PLANNING BOARD REPORT PORTLAND, MAINE

SUBDIVISION AND CHANGE OF USE/ RENOVATION OF BUILDING TO CREATE TEN APARTMENTS

415 Cumberland Avenue
Level III Subdivision Plan and Site Plan
Project ID #2015-162 CBL 036 G033001
Patrick Ducas, Applicant

Submitted to: Portland Planning Board Public Hearing Date: October 22, 2015	Prepared by: Jean Fraser, Planner Date: October 27, 2015
---	--

Drawing file: Oct 22 for hearing / Plan P2 Draft Subdivision Plat - Revised Civil Site Plan 10-22-15.pdf

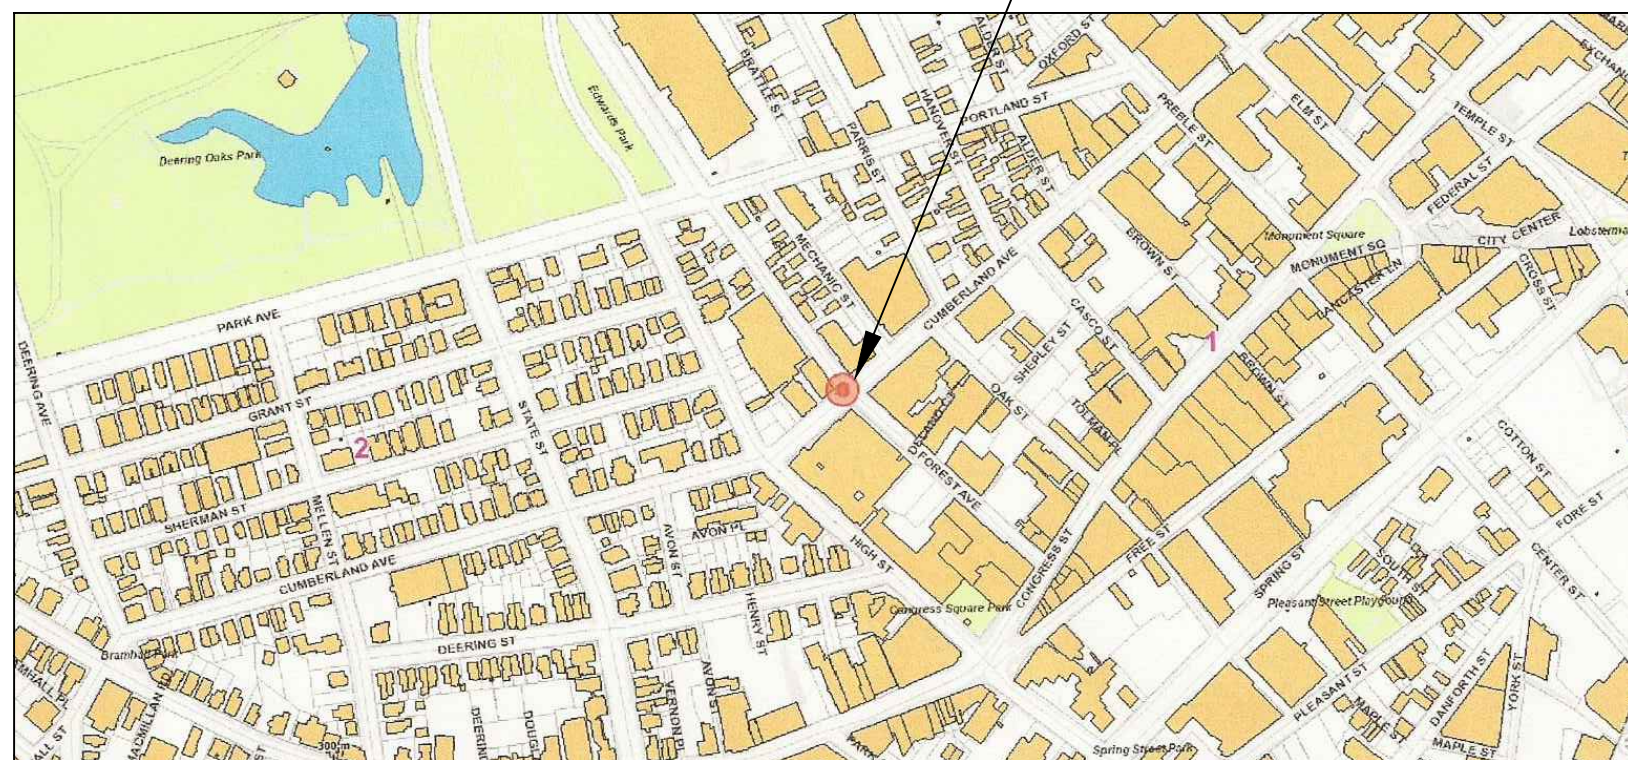
All requirements have been met. The subdivision plat (Plan P2.) has been reviewed by the Department of Public Services (DPS) Surveyor, the Legal Department and the Fire Department staff (Attachments 1, 4 and 5). The Legal Department and DPS Surveyor have requested clarification regarding the easements and other survey information; the draft plat in Plan P2 will need to be revised to address these comments.

A satisfactory enclosed and screened trash storage is provided near the existing curb cut in Forest Avenue (see Attachment H and Plan P2 for details). This location is near the YMCA and the applicant will need to ensure that these meet the zoning requirement that no dust nor fumes are created. A suggested condition of approval requires details of the proposed bike parking to be submitted for review and approval in order to meet the bicycle parking ordinance requirement for 4 spaces.

STAFF COMMENT: The sidewalks along the frontage are in good condition but the Department of Public Services has requested that the ramp panel within the tipdown at the corner crosswalk be replaced and the applicant is willing to make this improvement (as noted on the draft Plat/Site Plan in [Plan P2](#)). A suggested condition of approval includes this item in the request for detailed plans of work in the Right Of Way.

- i. That the applicant shall submit a revised site plan/plat that shows the location and design of the 4 bicycle parking spaces, the proposed planting in the front garden area including 2 street trees on the site, and the replacement ADA ramp panel in the ROW at the corner of Forest Avenue and Cumberland Avenue (to meet the City's Technical Standards for any work in the ROW), for review and approval by the Planning Authority prior to the issuance of a building permit; and

5 Top Roof drainage plan
1/4" = 1'-0"

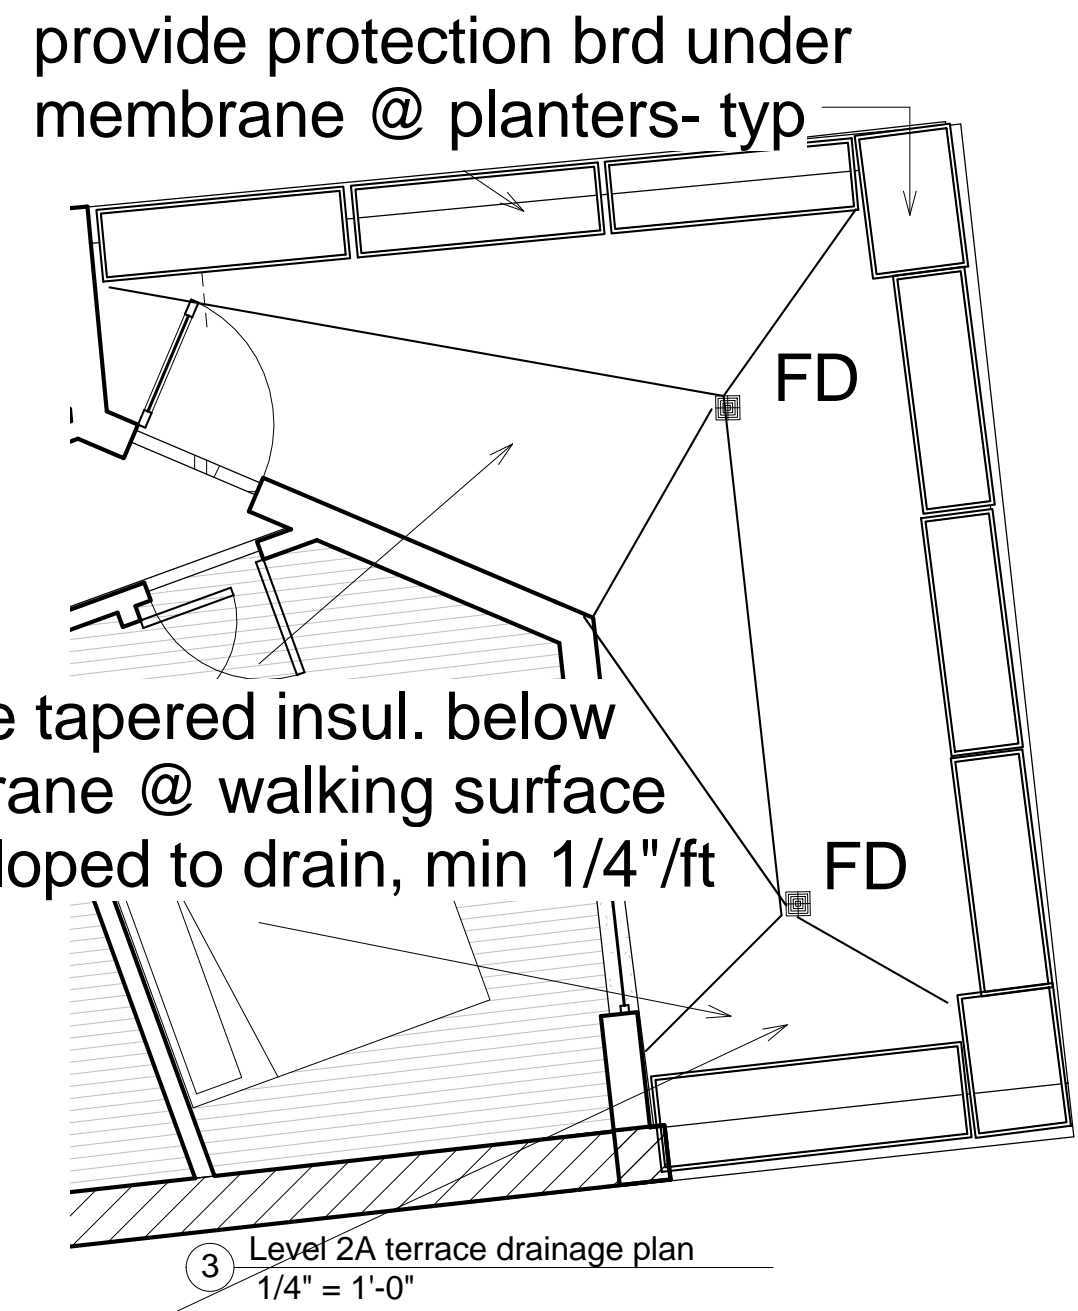
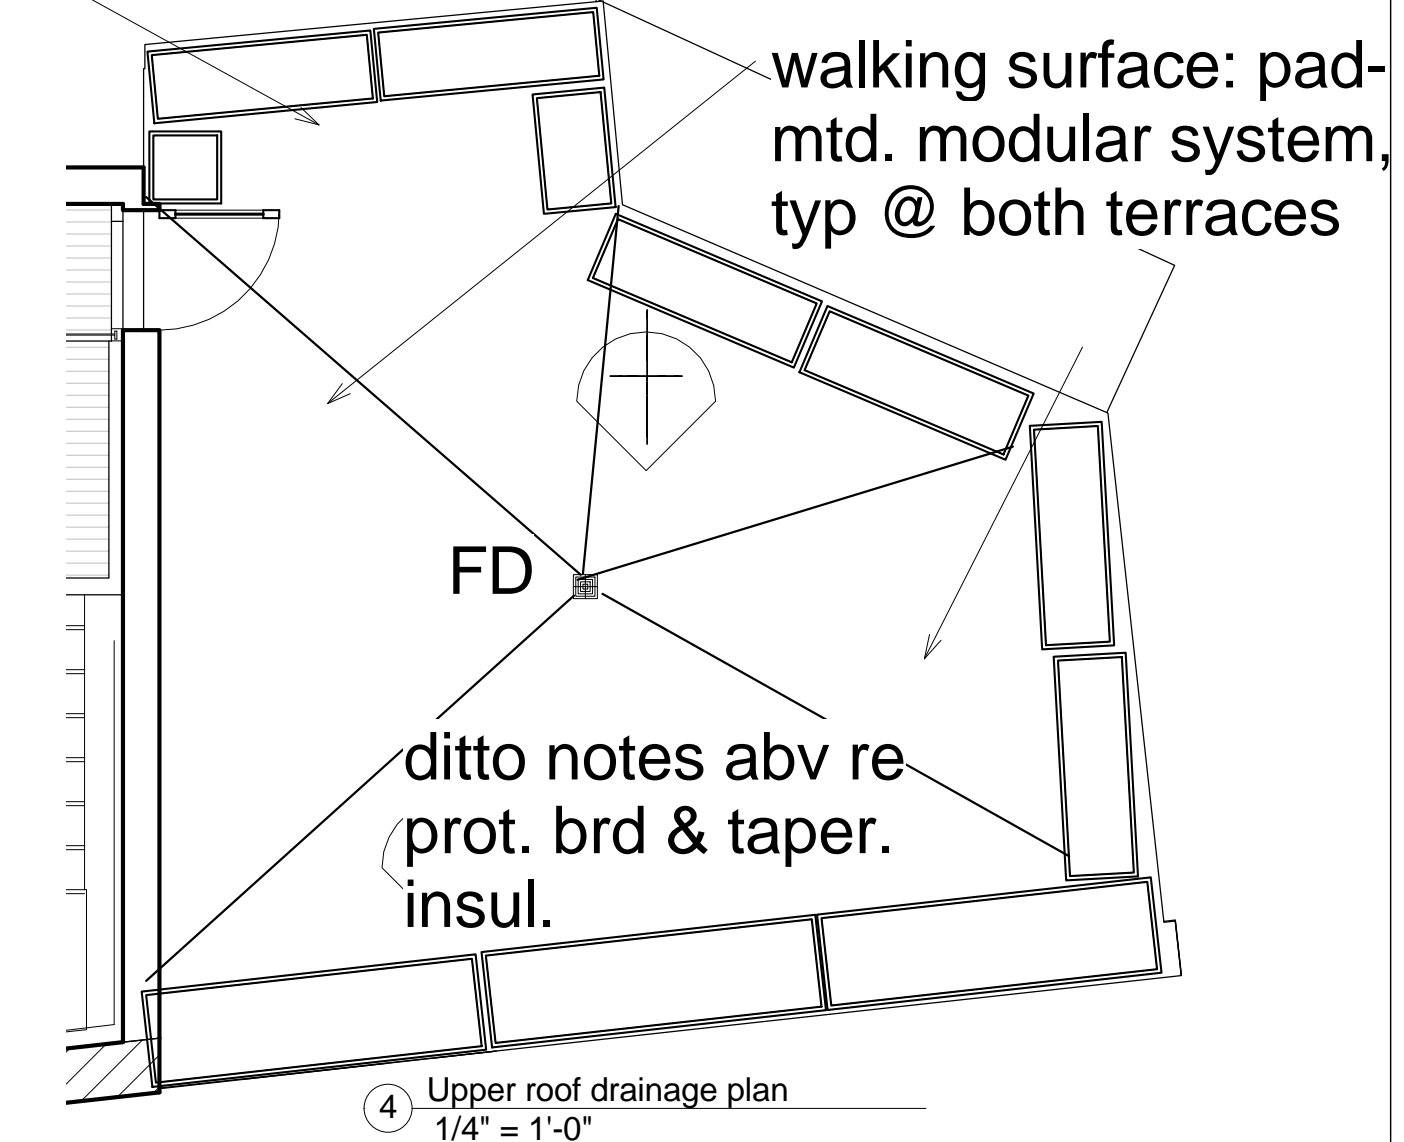
The reuse of the building does not require any upgrading to meet current stormwater requirements, but the DPS in their Wastewater Capacity letter ([Attachment 1](#)) has requested that all rainwater downpipes be directed to the sidewalk or street level and not be connected to the sewer. The applicant is checking on whether a central roof drain is connected to the sewer and the suggested condition requires that if there is a connection that the proposals to redirect that drainage be submitted for review and approval.

- ii. That the applicant shall submit plans showing the proposals for: A) Any modifications to the roof drainage to meet the Wastewater Capacity Letter conditions (that all roof drainage be directed to the sidewalk or street level); and B) All upgrades to the existing water and sewer utilities at the existing locations, including restoration of the sidewalk (to meet the City's Technical Standards for any work in the ROW); both for review and approval prior to the issuance of a building permit; and
